WEST SUSSEX COUNTY COUNCIL CONSULTATION

TO:	Arun District Council FAO:Ms M Tomalova
FROM:	WSCC - Highways Authority
DATE:	7 June 2021
LOCATION:	Church Farm Holiday Village Church Lane Pagham PO21 4NR
SUBJECT:	P/71/21/PL Installation of arrivals lodge with associated infrastructure and ancillary landscaping works. This site is in CIL Zone 4 (Zero Rated) as other development & may affect the setting of a listed building.
DATE OF SITE VISIT:	n/a
RECOMMENDATION:	Advice
S106 CONTRIBUTION TOTAL:	n/a

Drawing Title: **Block Plan**

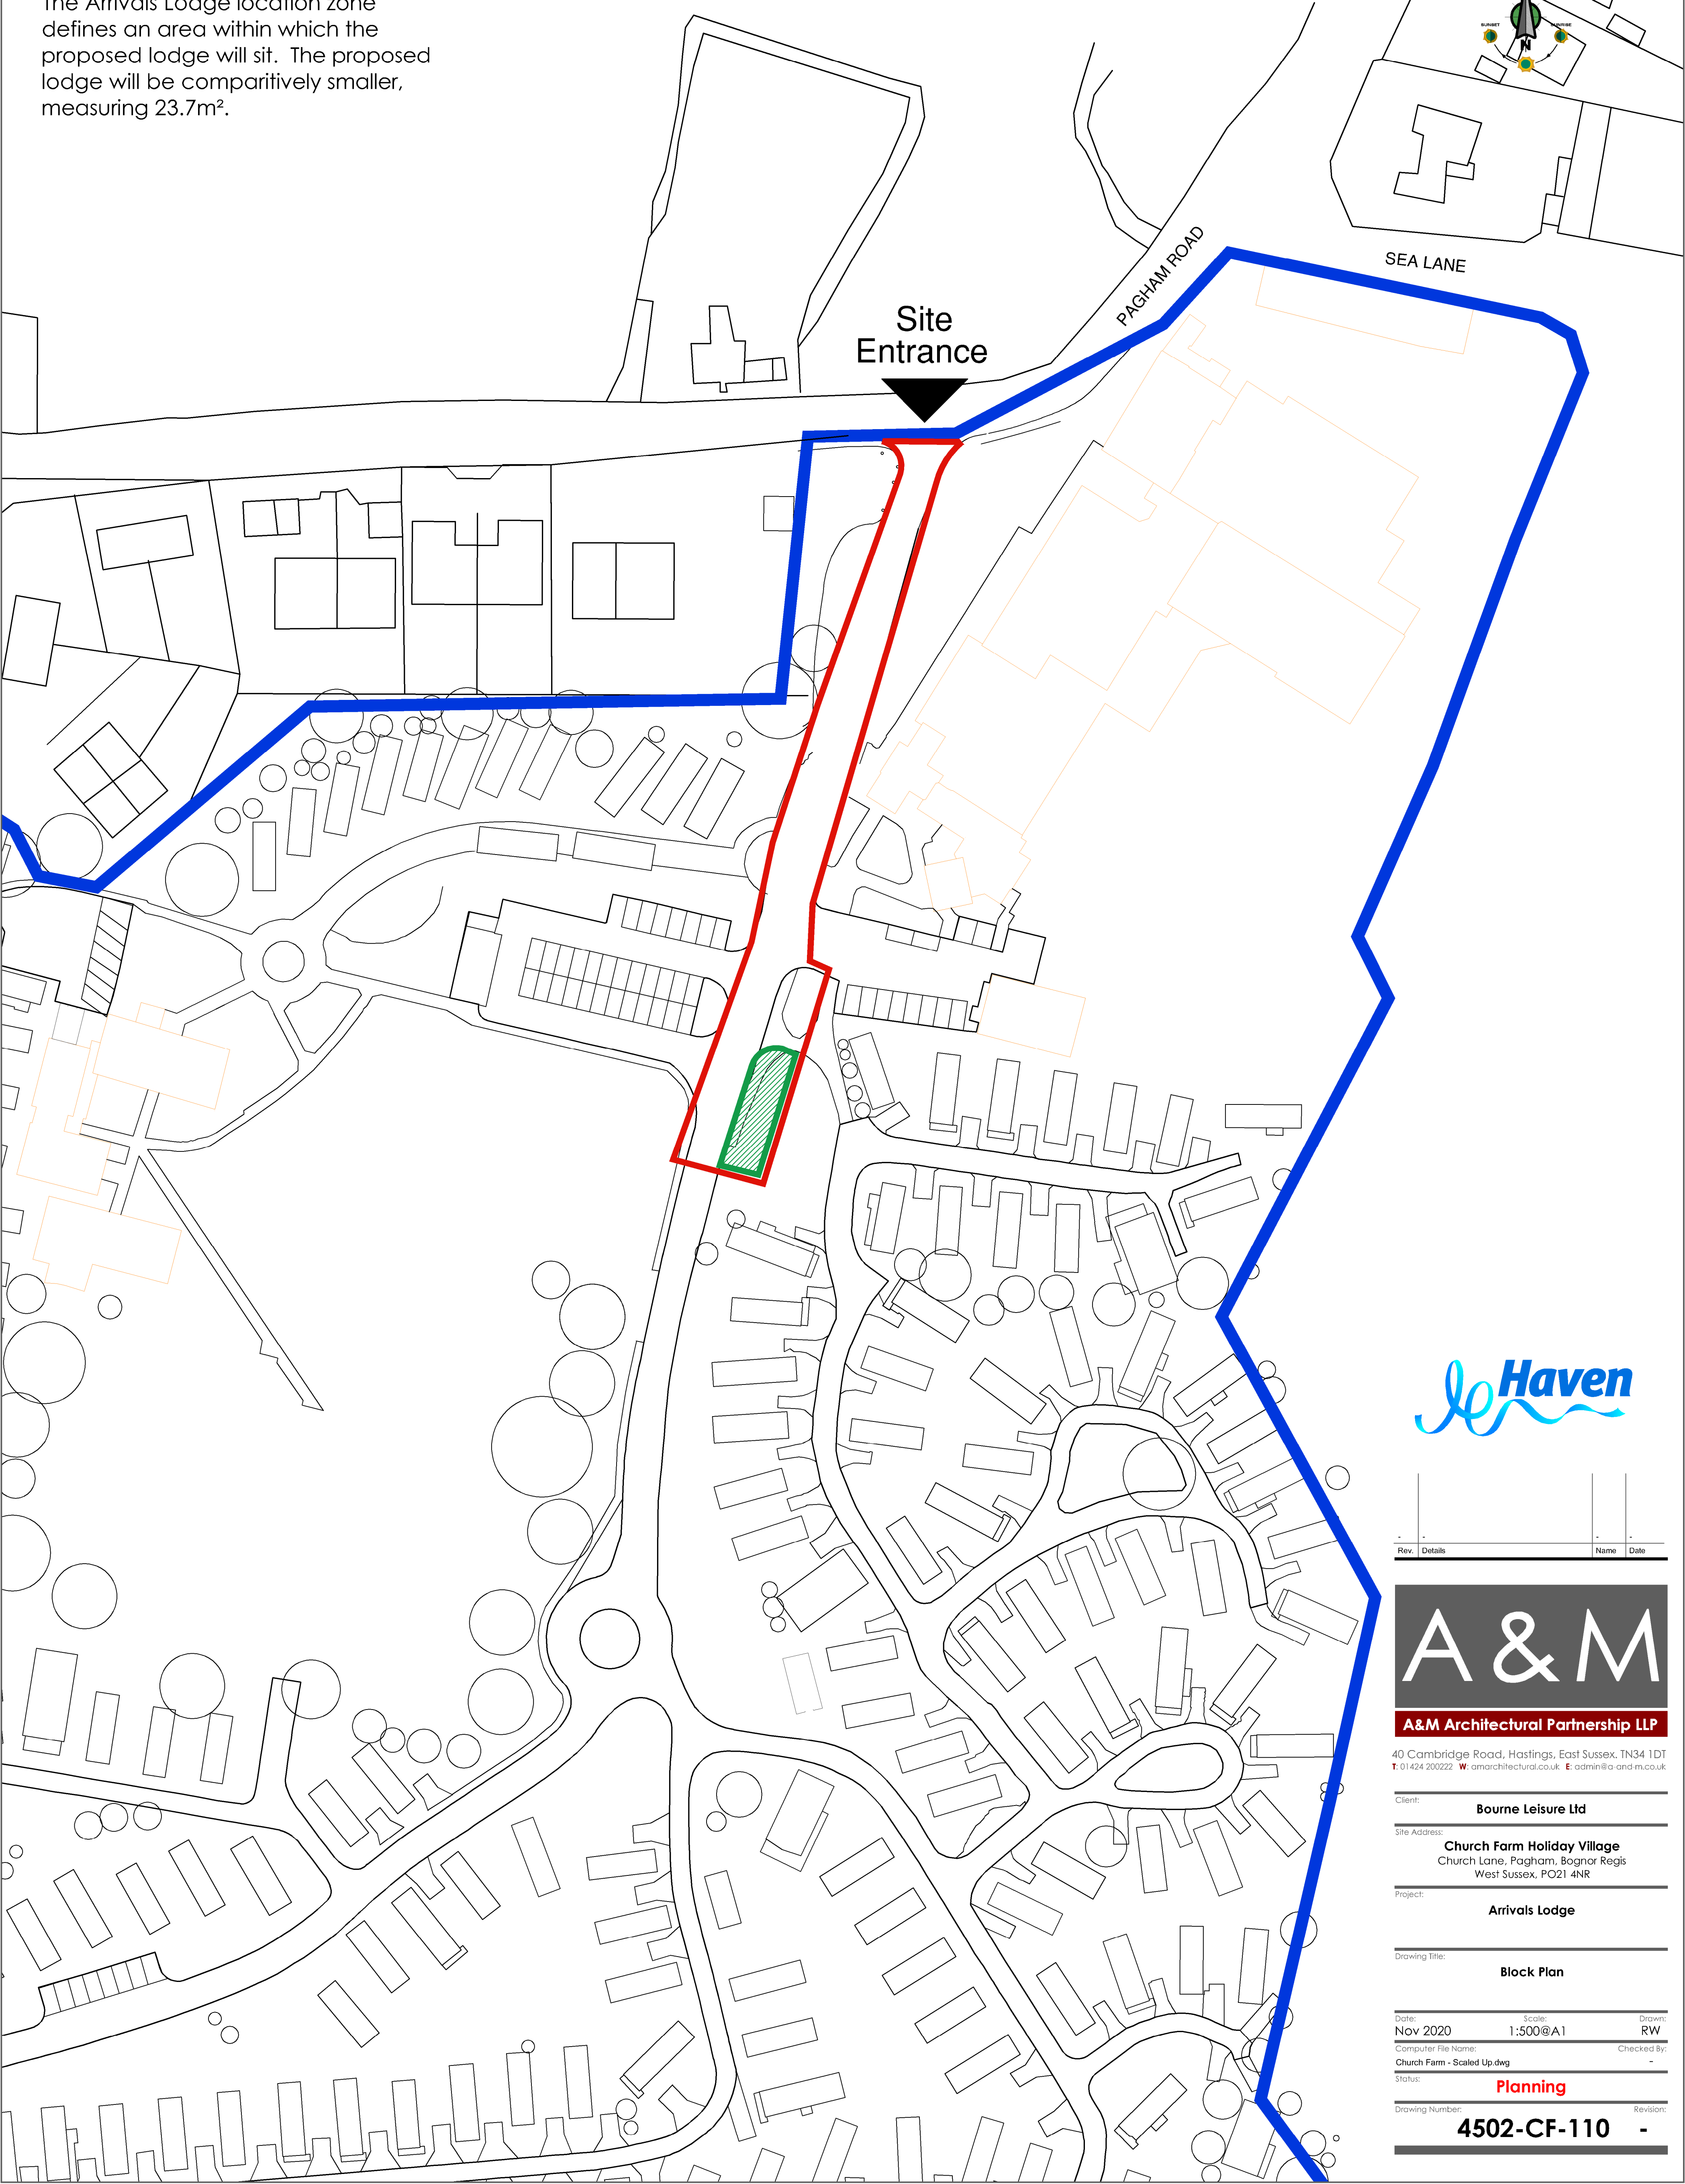
The proposal is to provide sheltered area for welcome and security staff. The total gross floorspace of the proposed lodge is 21sqm. The WSCC Car Parking Guidance outlines that 1 parking space is

required for this development (1 space per 22sqm for D2 use). The proposed site plan demonstrates 2 parking spaces situated adjacent to the lodge and these accord with the minimum requirements of 2.4 x 4.8m per bay as outlined in Manual for Streets (MfS) guidance.

No part of the development shall be first occupied until the car parking spaces have been constructed in accordance with the approved site plan. These spaces shall thereafter be retained at all times for their designated purpose.
